Our Ref: FP/217/20/NMA

Non material amendment following grant of planning permission FP/239/19/PL to replace small section of 1.2m close board fence with 1.2m post and rail fence, and addition of guard railings adjacent to northern gate.

Felpham Site 6 Westmorlands Drive Fekpham

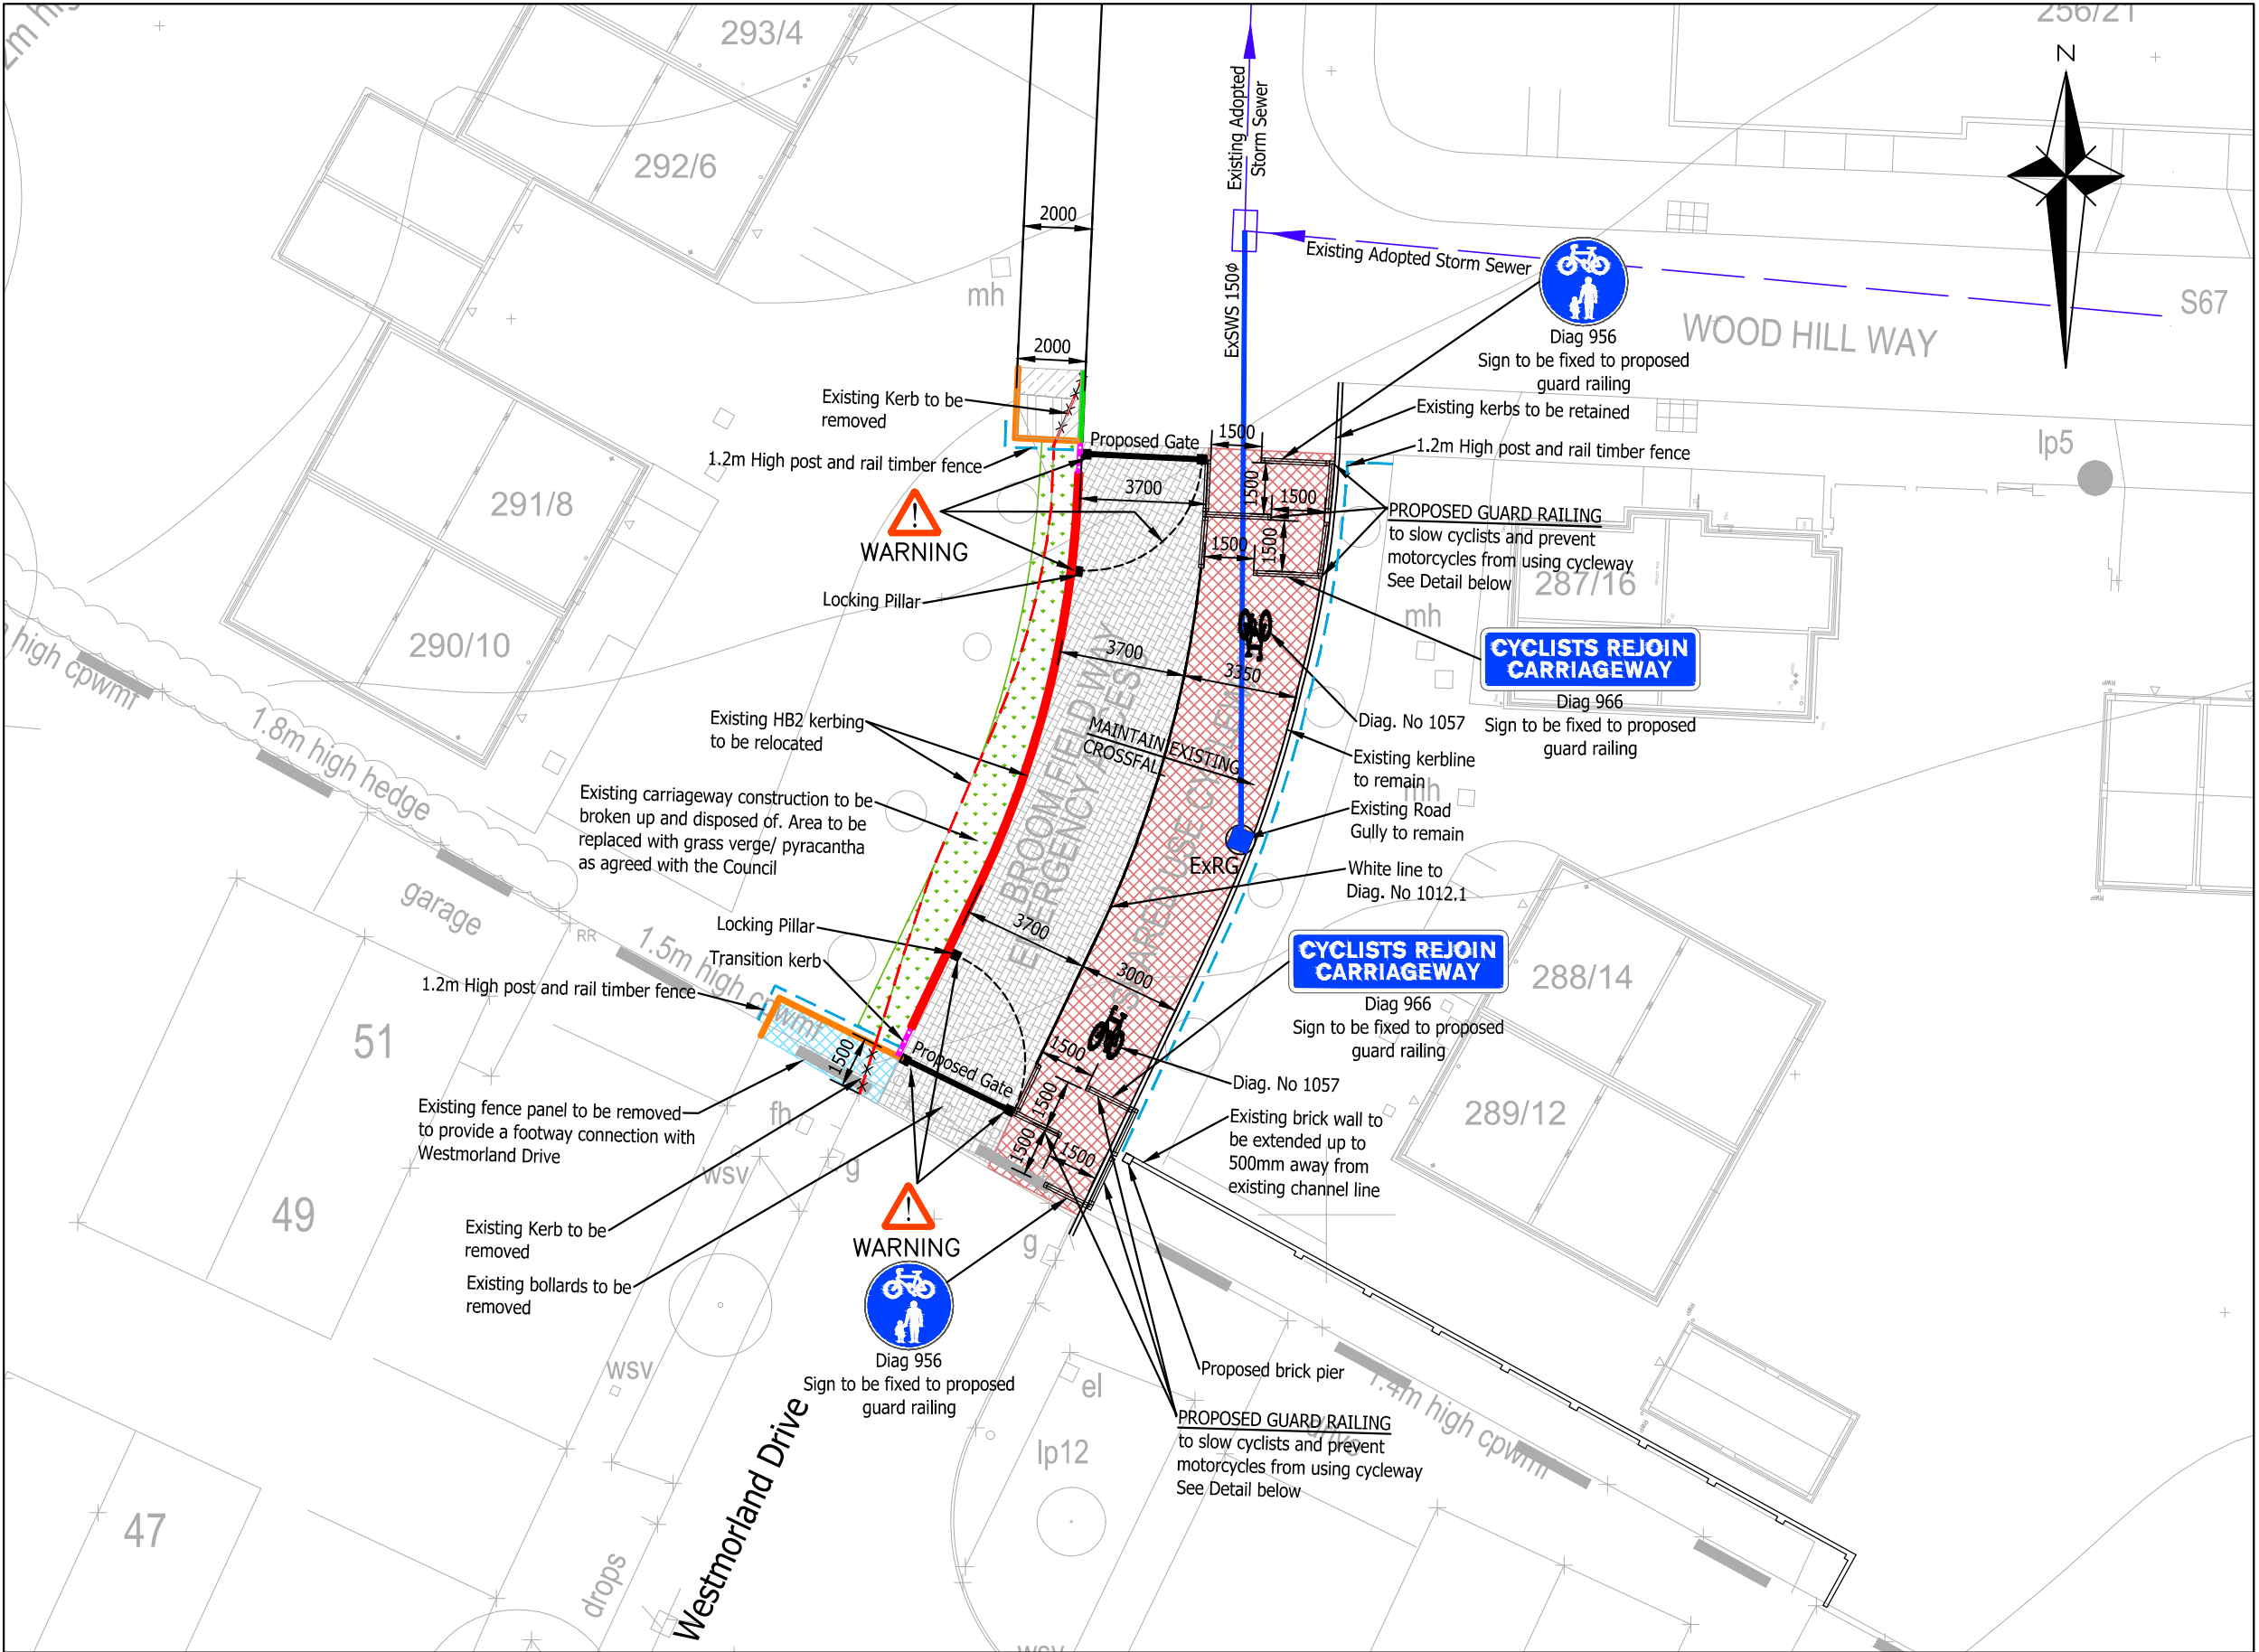
The reasons that these proposals have not been accepted as Non-Material Amendments is because the revision to the layout and appearance of the emergency vehicle access gates at the end of Westmorland Drive comprising the replacement of a small section of 1.2 metre close board fence with 1.2 metre post and rail fence, and the addition of guard railings adjacent to the northern gate constitute amendments that have a material impact on neighbouring residents and would warrant re-consultation either of neighbours, council departments or statutory bodies, and it can therefore cannot be considered under section 96A of the Town and Country Planning Act 1990.

From the information submitted I am not prepared to take the alterations as a Non-Material Minor Amendment to planning permission (FP/239/19/PL) at Site 6, Felpham (also known as Blake's Mead). A separate planning application is required to be submitted.
